Current Zoning: UMUD(O) (Uptown Mixed-Use District, optional).
Proposed Zoning: UMUD(O) SPA (Uptown Mixed-Use District, optional, site plan amendment).

Approximately 0.42 acres located on the east corner of East 8th Street and North College Street, and west of East 9th Street.

The petition proposes a site plan amendment to petition 2010-065 to eliminate off-street parking requirements. The site is currently developed with a hotel.

RZP-2025-041

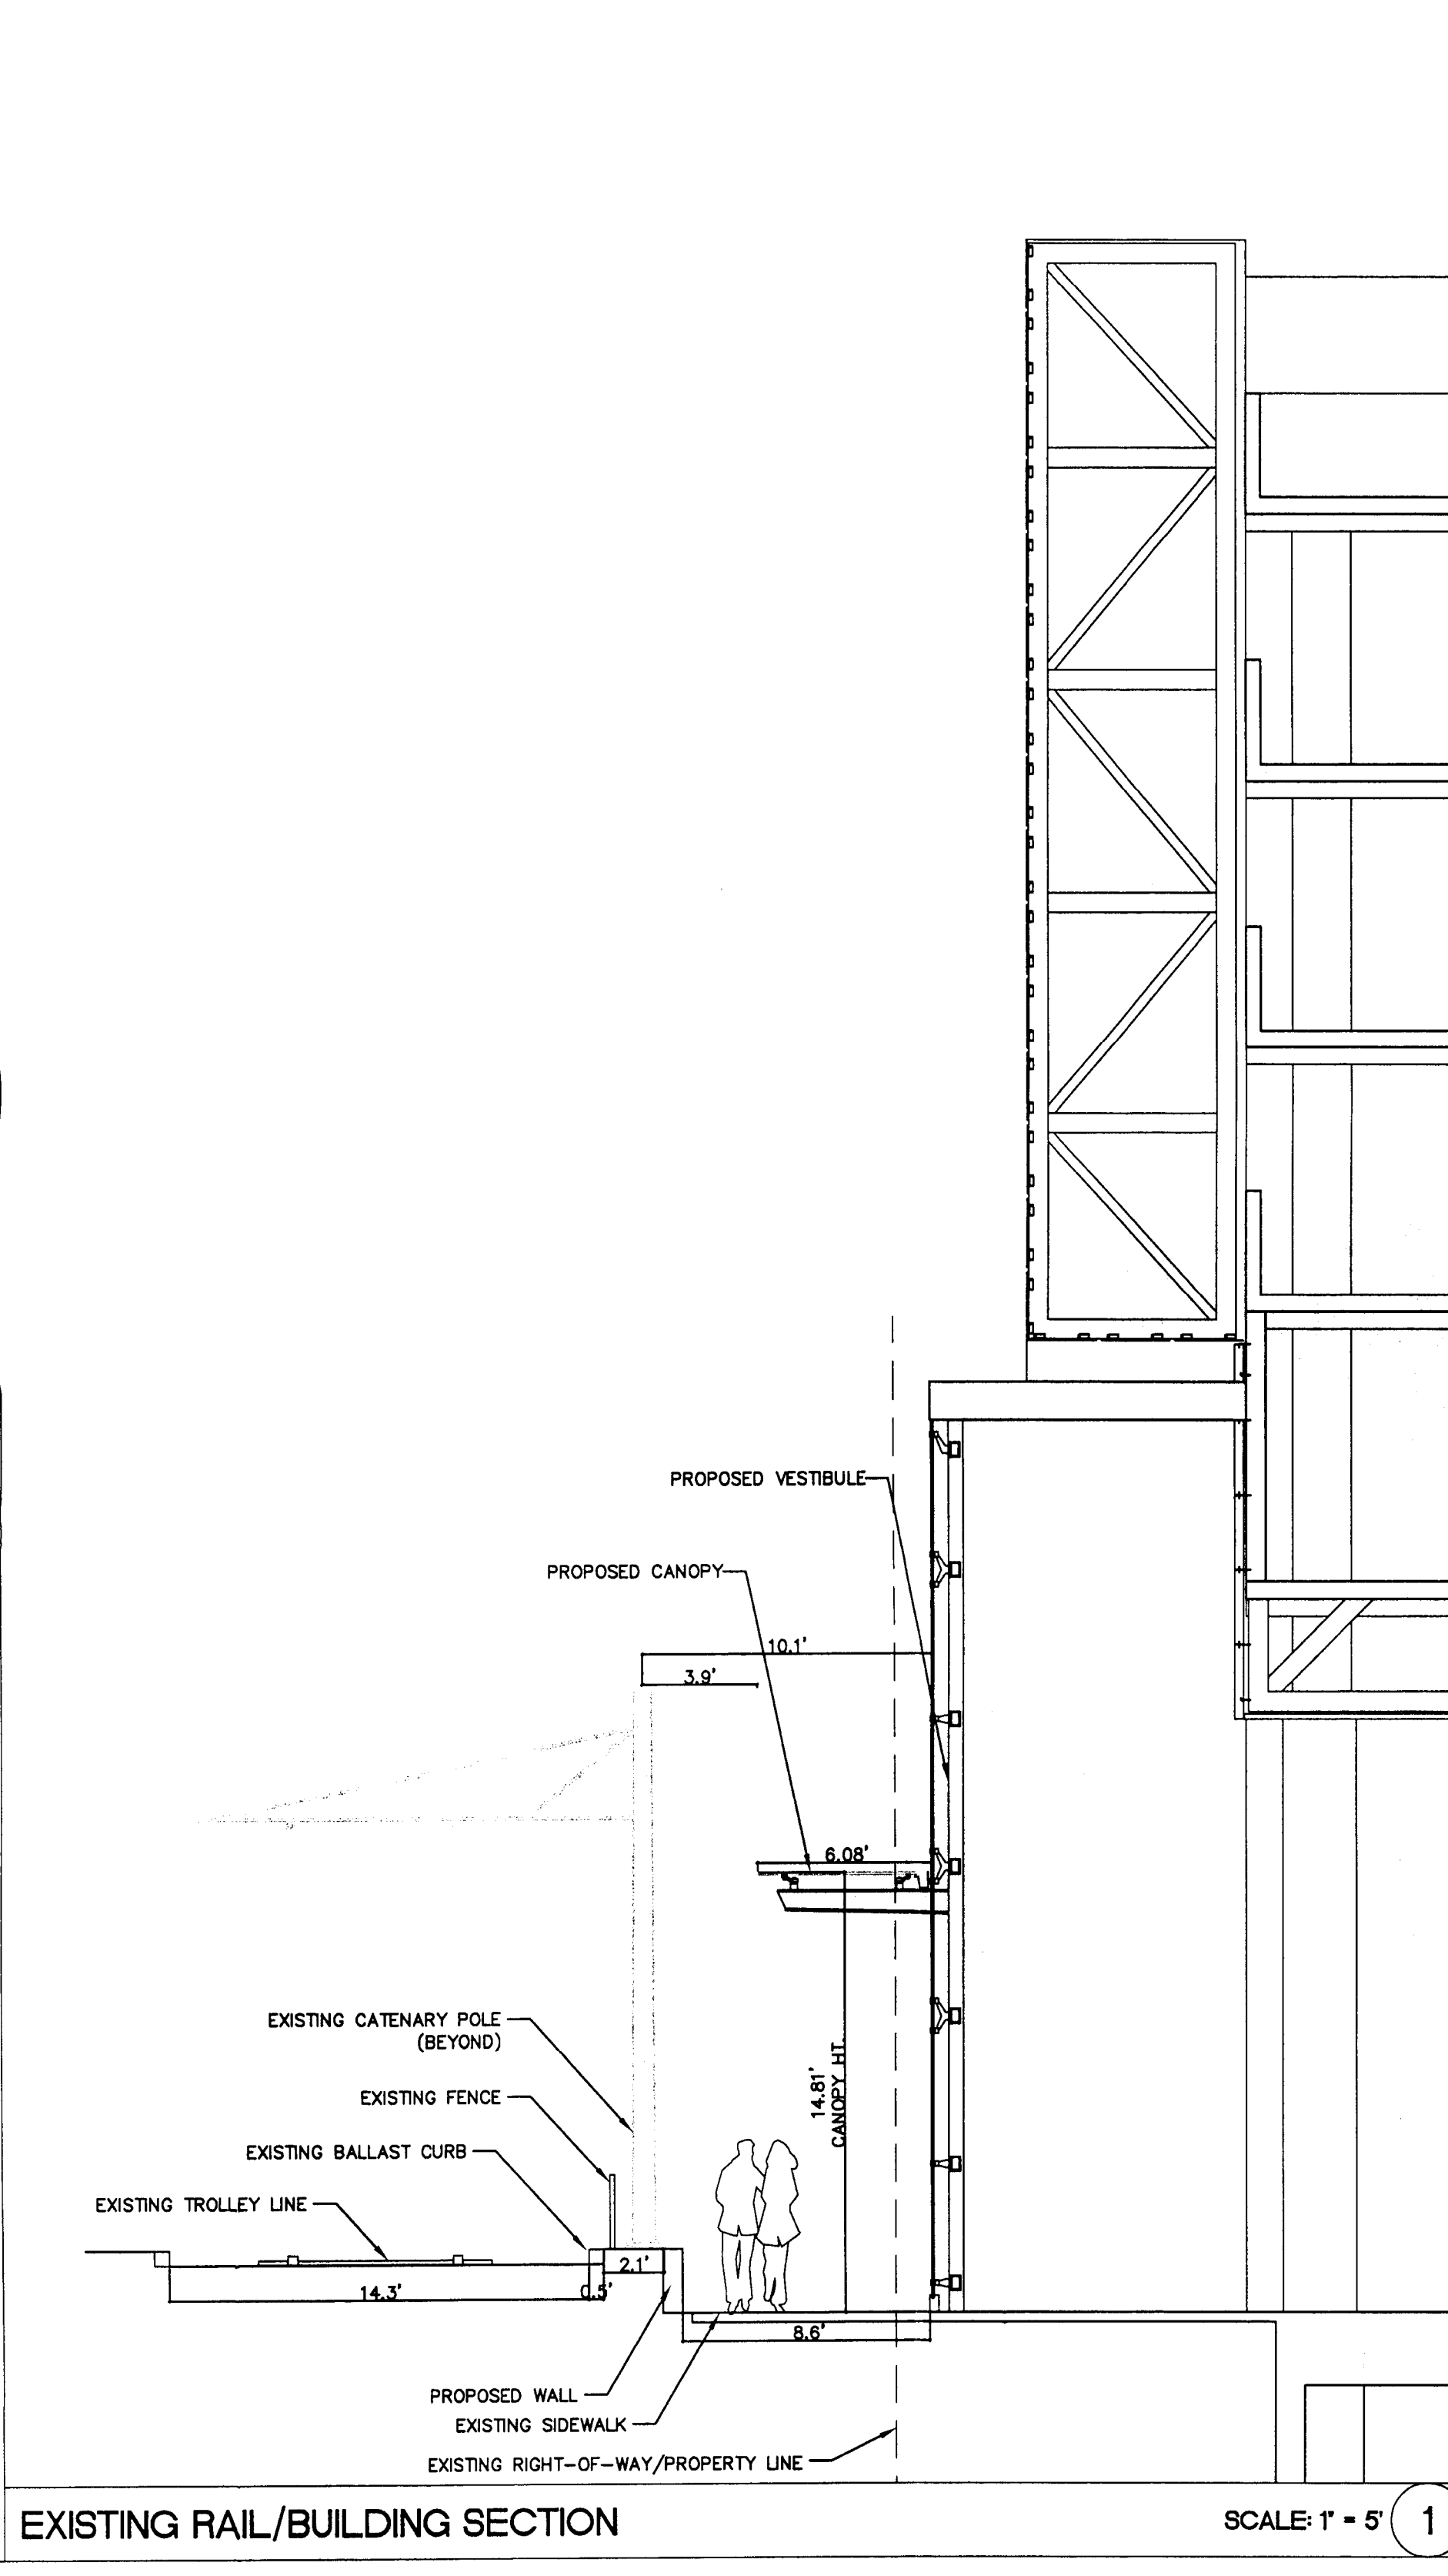
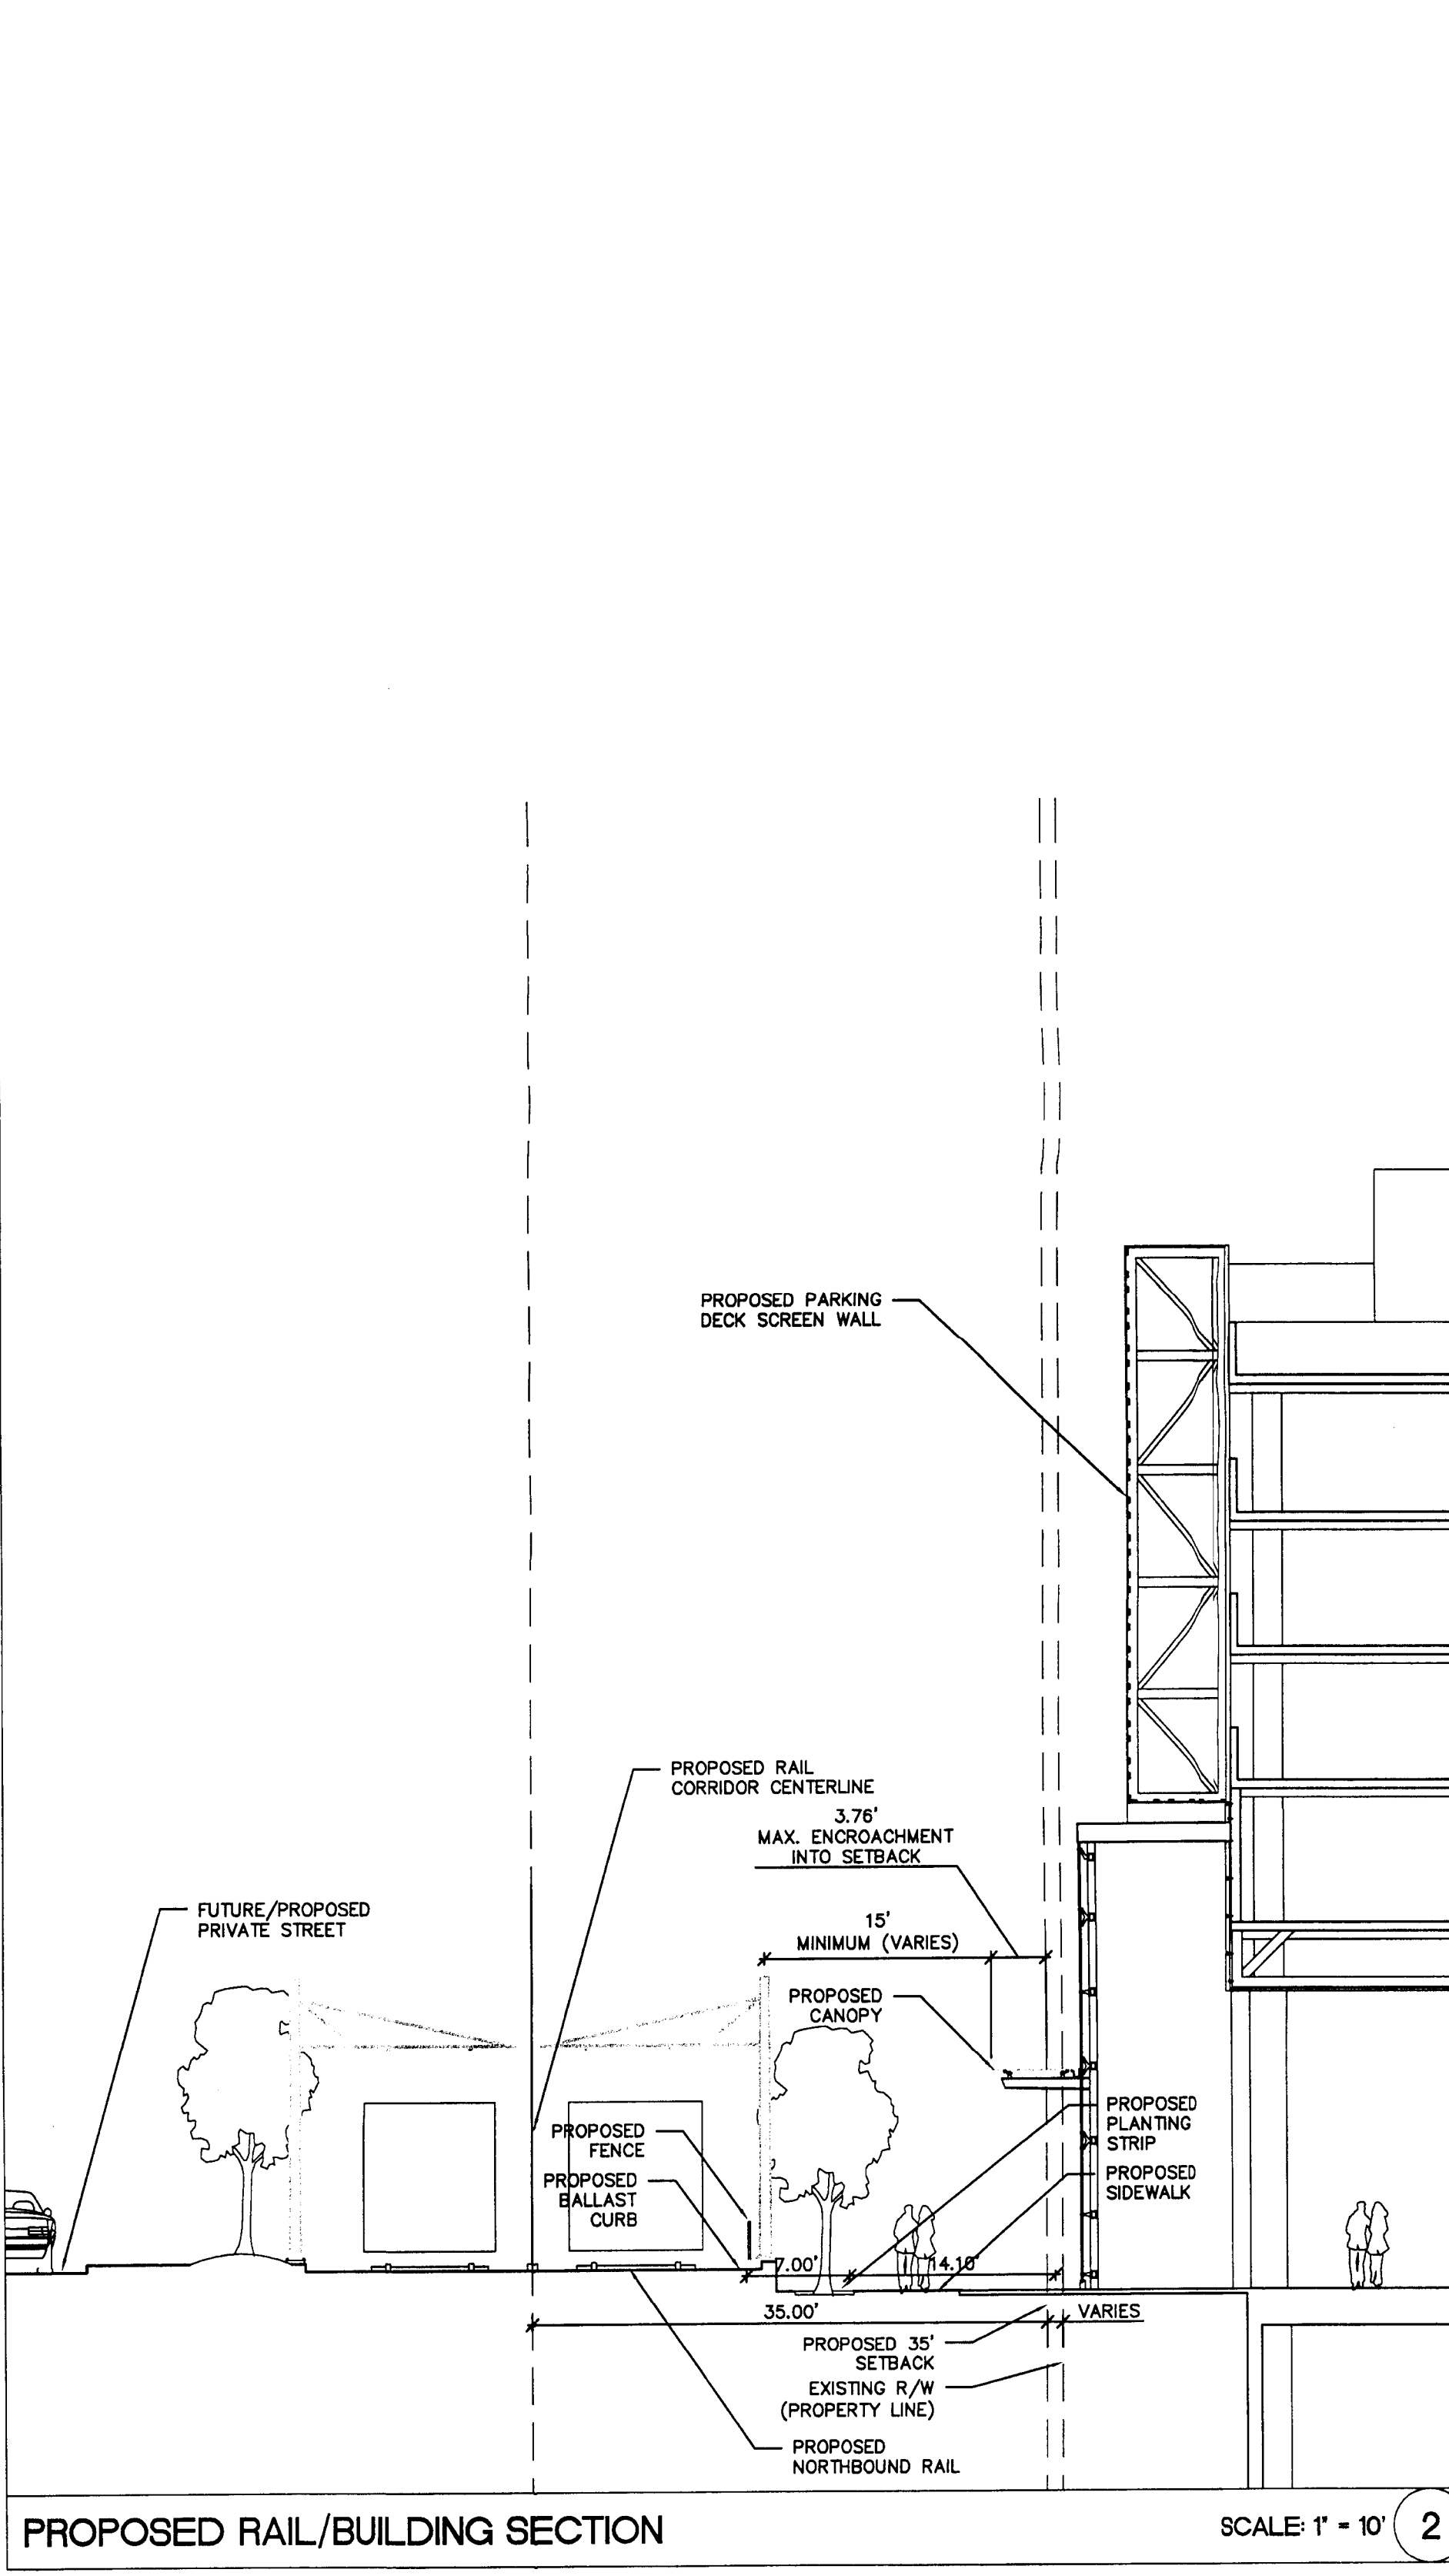
1. ~~Entitlement Services: Add rezoning petition number to site plan.~~ Addressed
